Freedom Forever
Planset Revision Letter

11/12/2024
REV #2

SHATACA HICKS
237 BEACON HILL ROAD, LILLINGTON, NC 27546

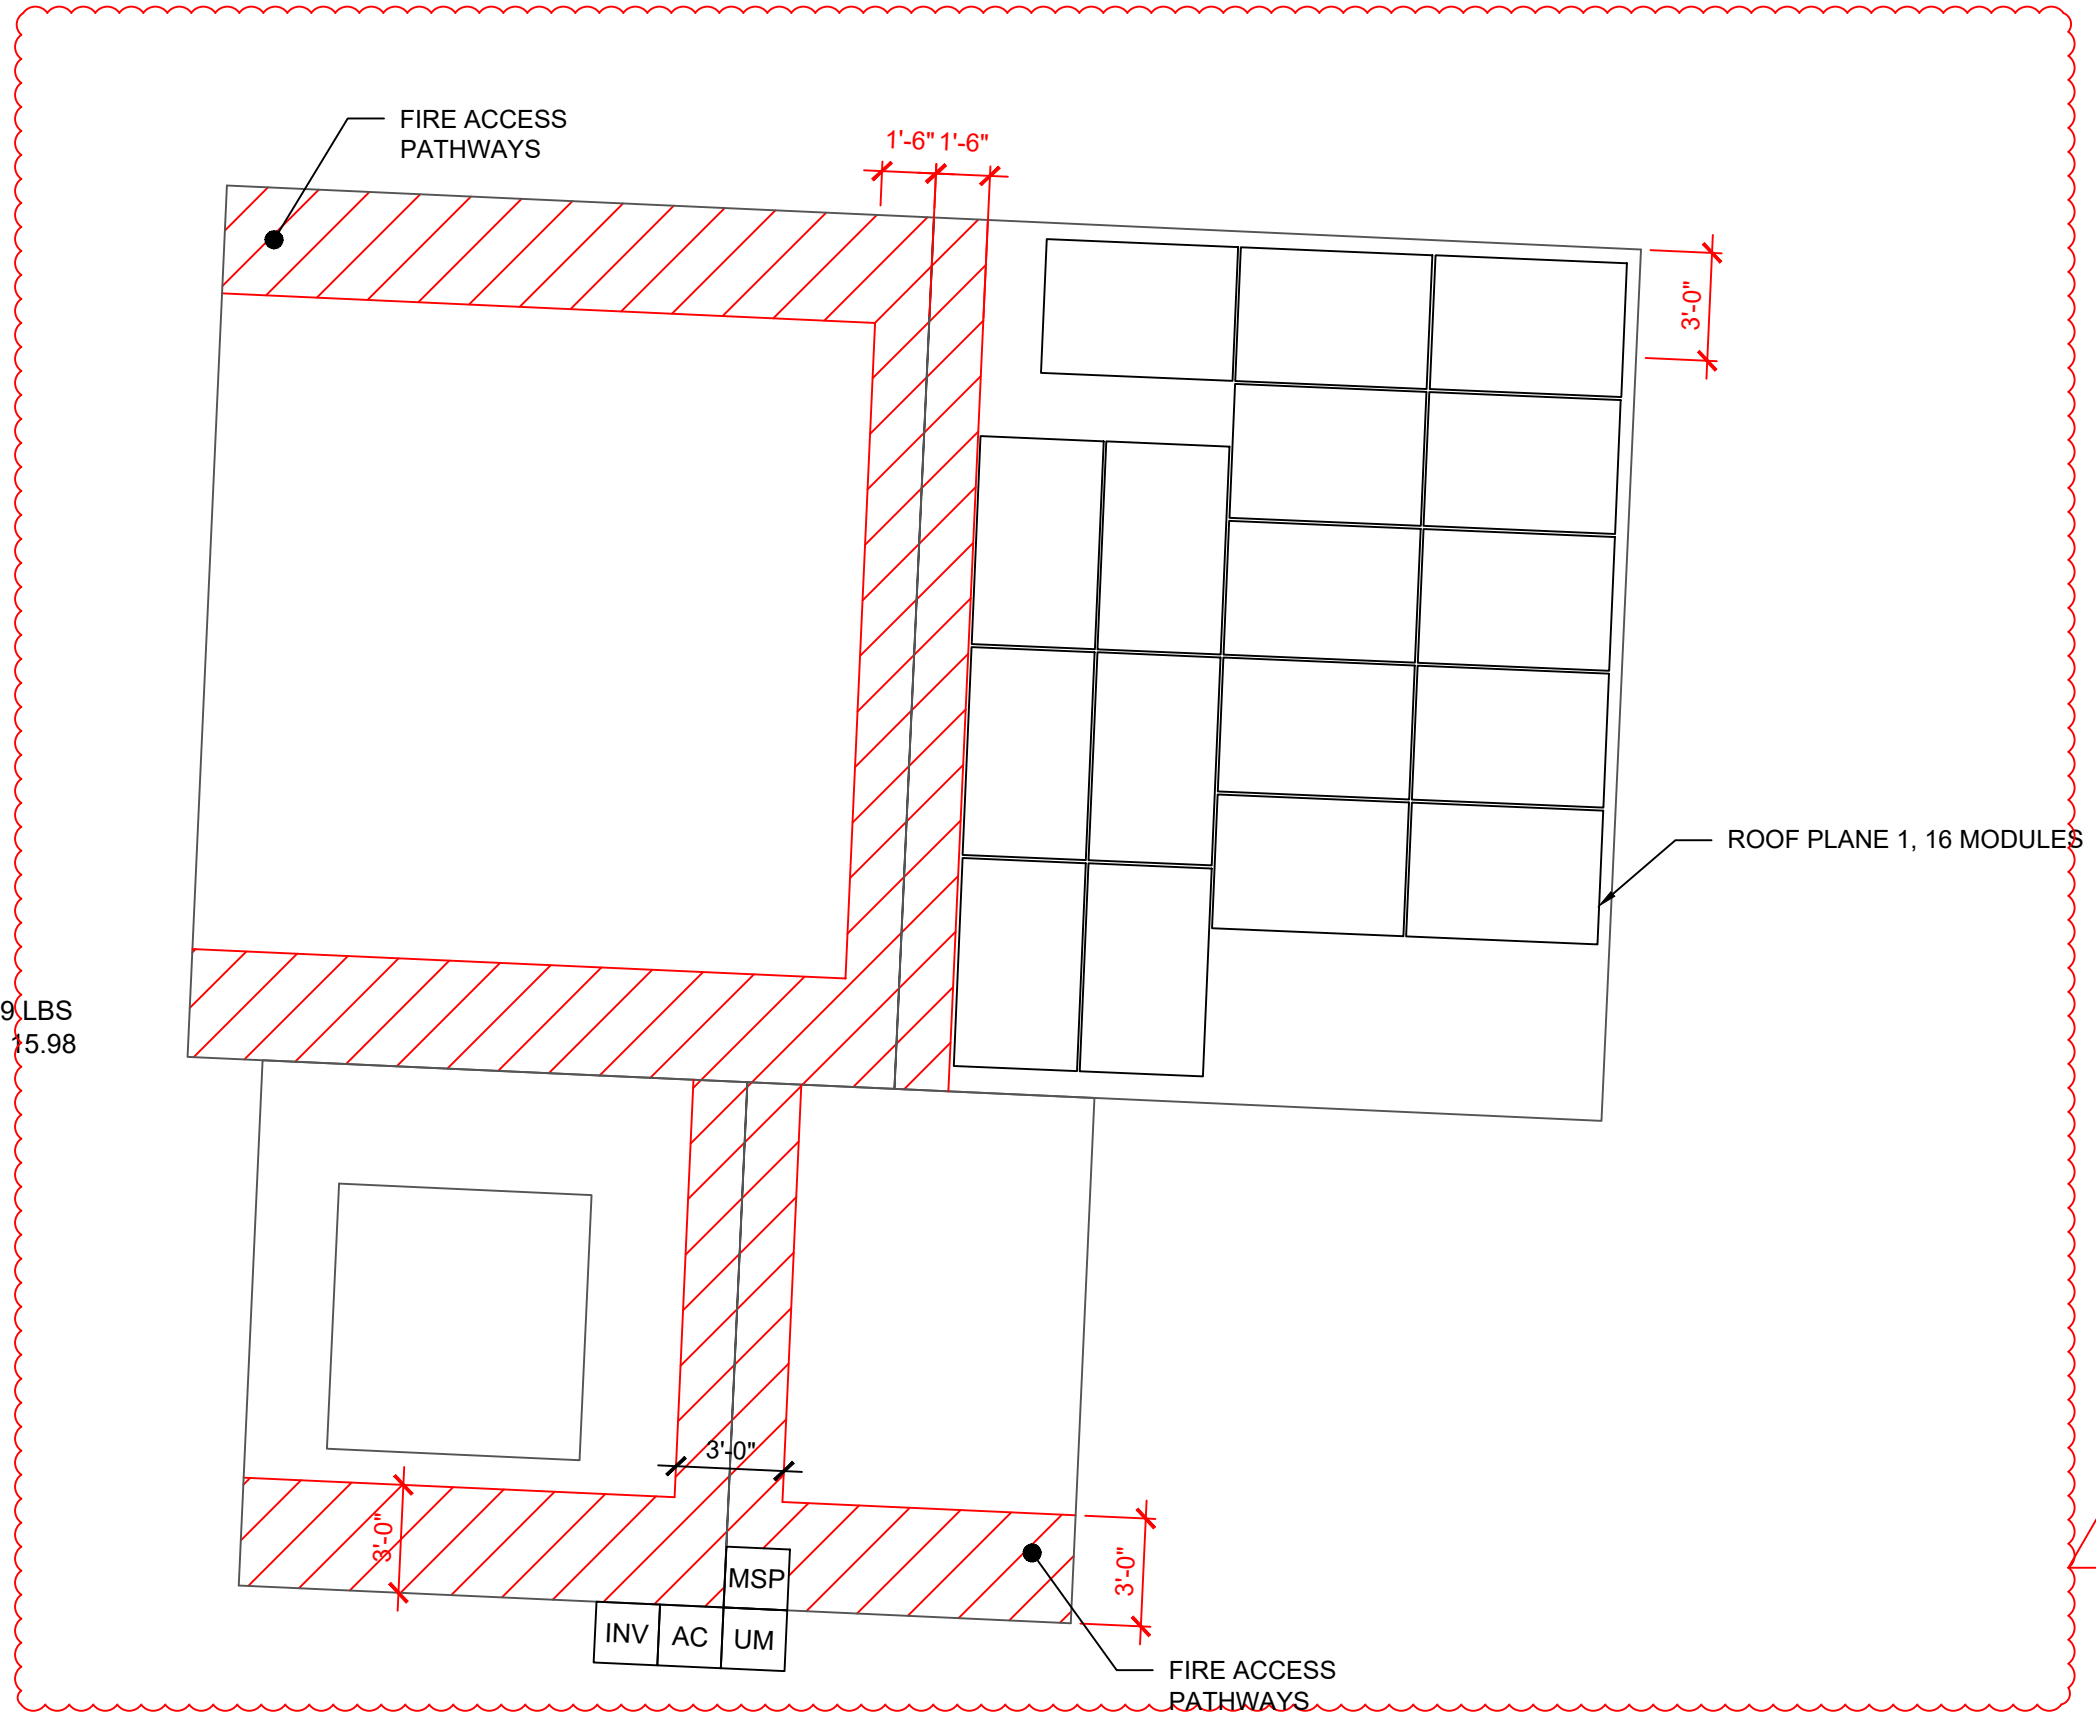
REV#2

Layout changed to match installed layout

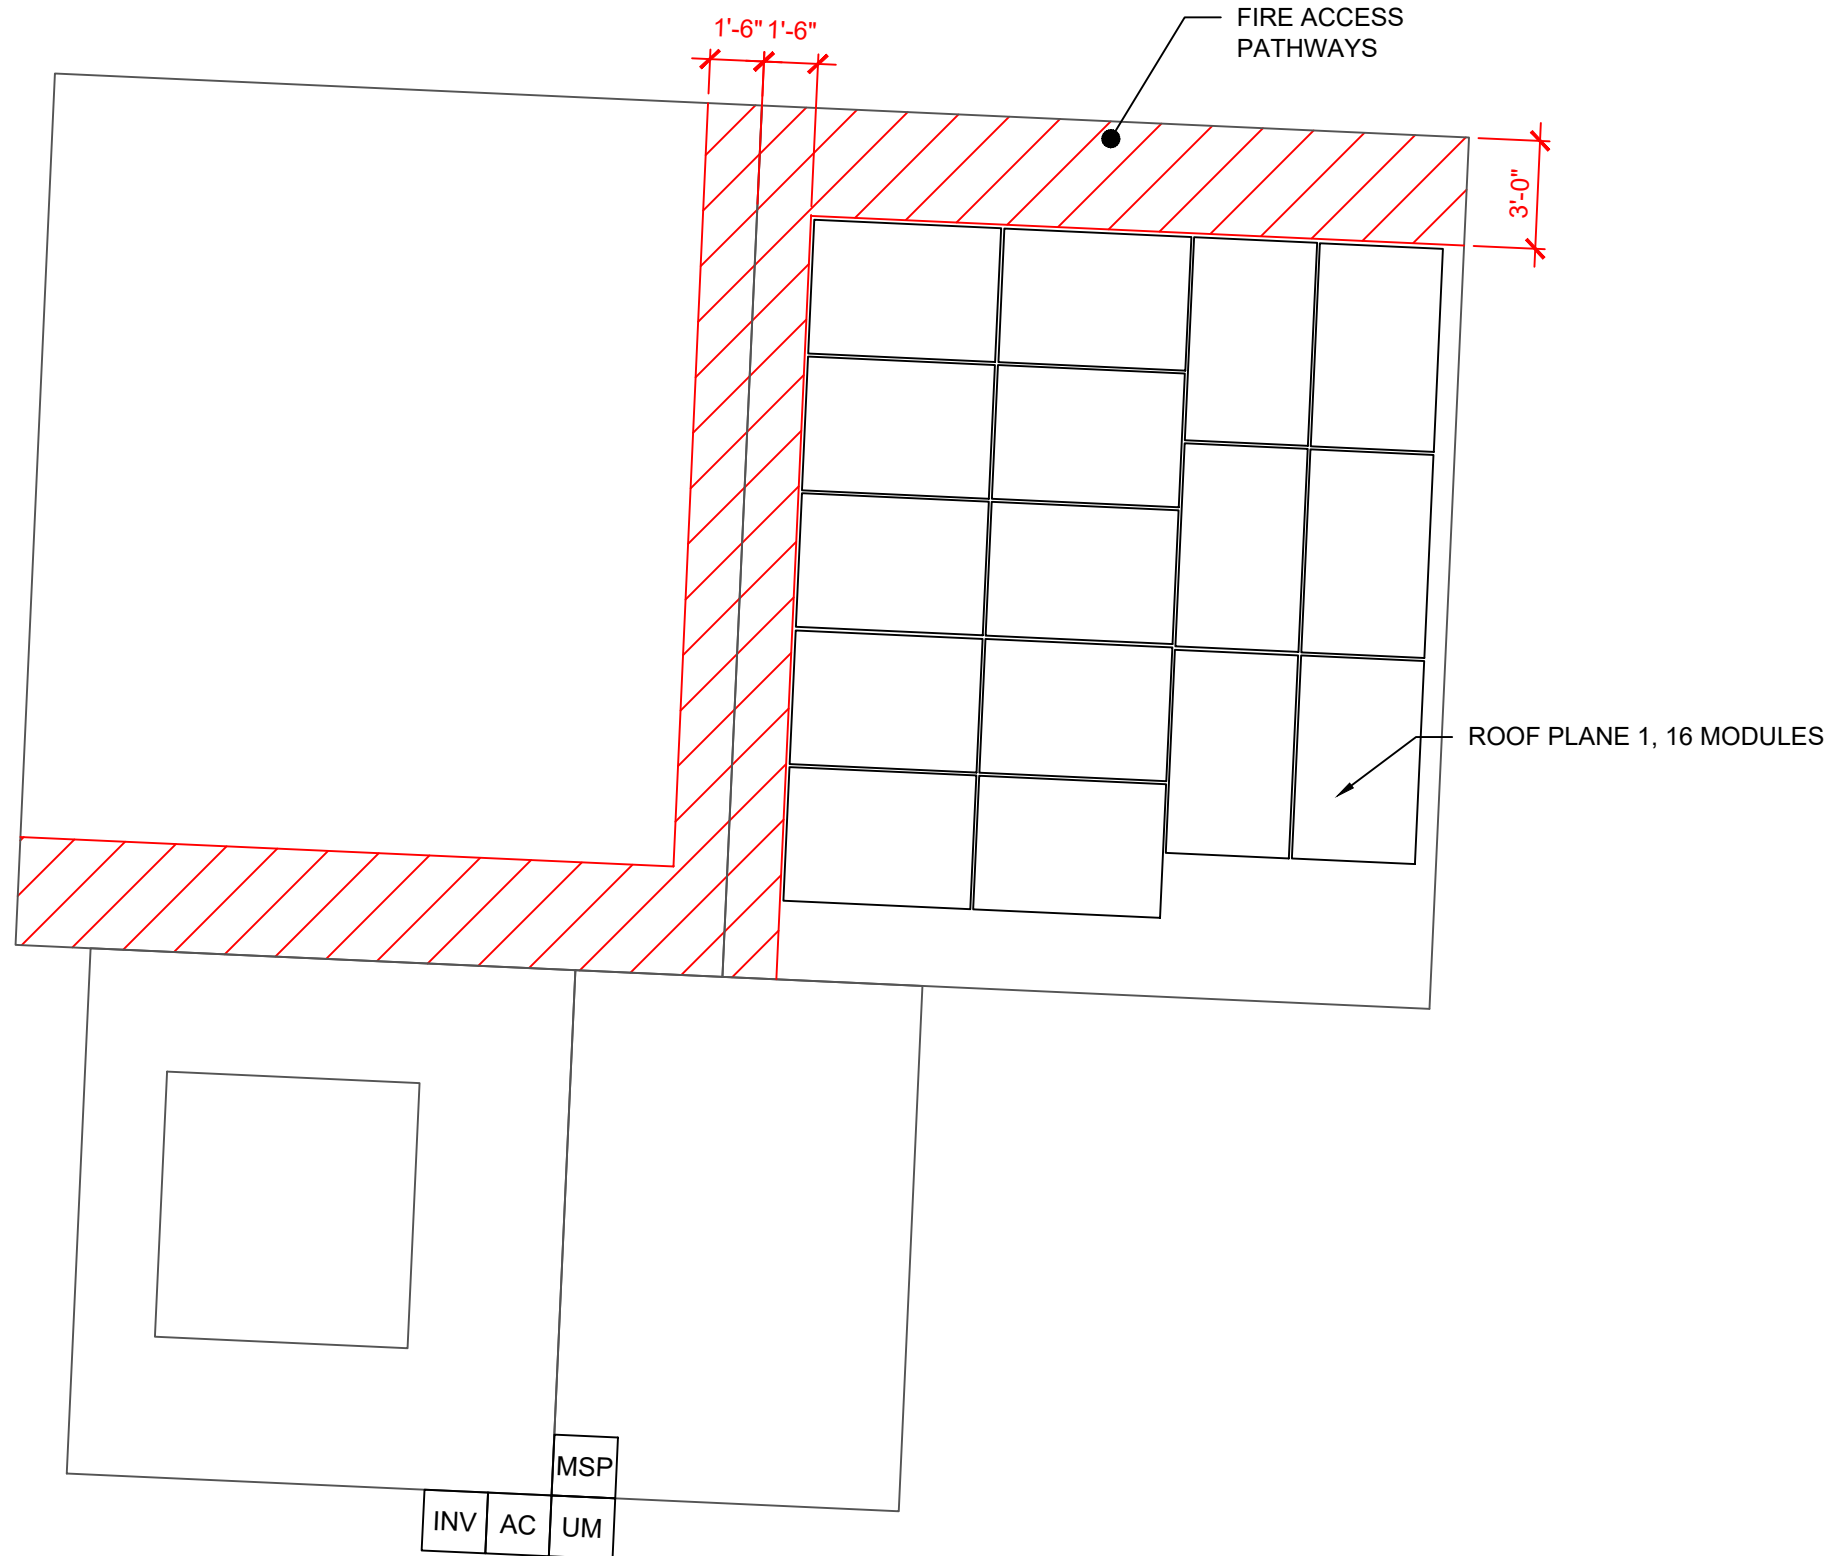
REV#1

Module swapped to Silfab 430 to Trina 410
